**KIRKLEES METROPOLITAN COUNCIL
INVESTMENT & REGENERATION SERVICE**

**DELEGATED DECISION TO DETERMINE APPLICATIONS FOR
CONSENT, AGREEMENT OR APPROVAL REQUIRED BY CONDITION**

Reference No:	2025/44/90678/E
Site Address:	5-7, Ossett Lane, Earlsheaton, Dewsbury, WF12 8LU
Description:	Discharge of details reserved by conditions 5 (noise), 8 (boundary treatments) on previous permission 2023/90833 for Reserved matters application pursuant to outline permission 2021/91695 for erection of residential development (5 dwellings)
Recommending Officer:	Nina Sayers

DECISION – Discharge of Conditions – Split Decision

**Figure 1: Noise Measurement Locations**

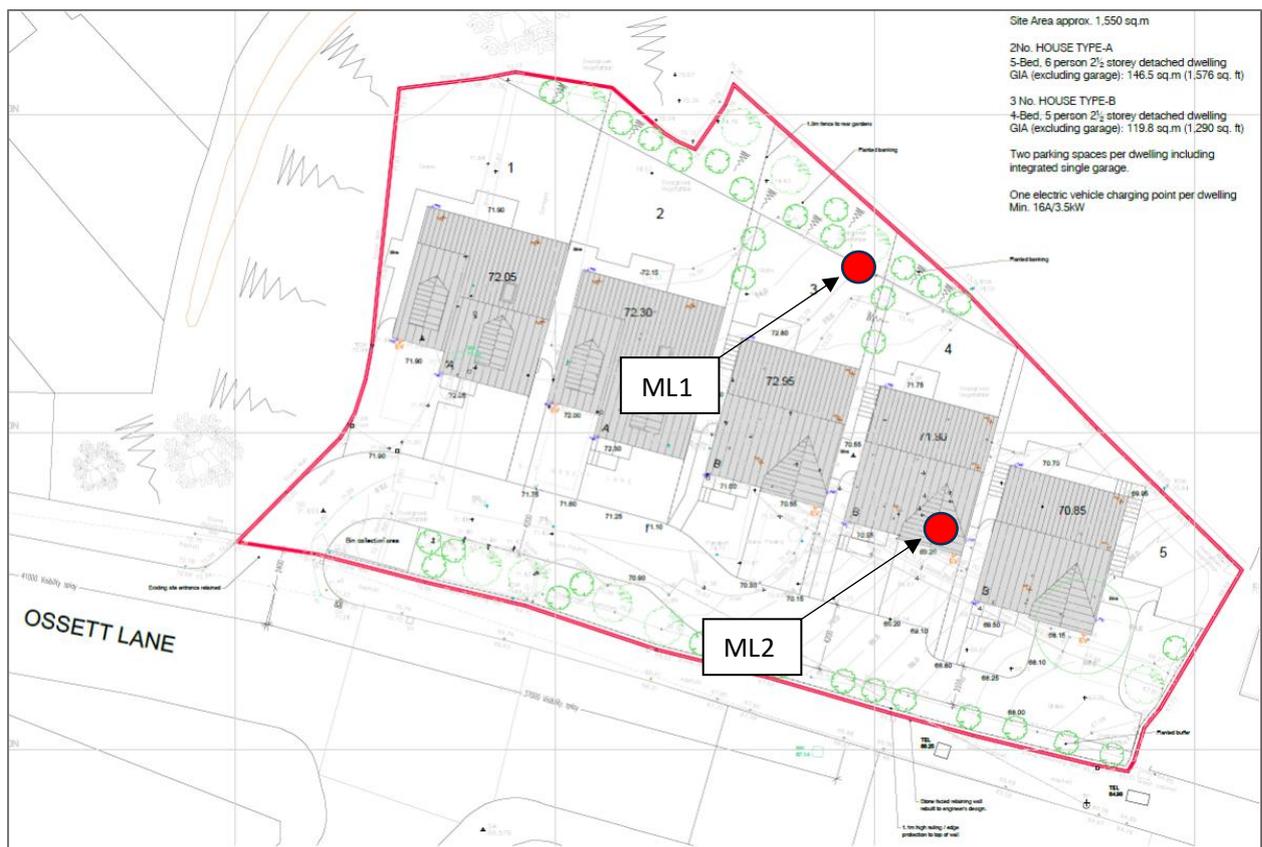
The report makes reference to the findings of the approved report submitted under the previous permission and the requirements of the condition. It also provides details of a noise survey which was undertaken over a 24hr period on Thursday the 13th of February 2025 from two measurement locations as shown

in Figure 1. A summary of the findings are given in tables 3 and 4 which shows that the development will meet with the requirements of BS8233 for both internal and external areas.

KC Environmental Health have reviewed this report and are satisfied that the submitted report is acceptable for the purposes of discharging condition 5.

Condition 5 can therefore be discharged at this time.
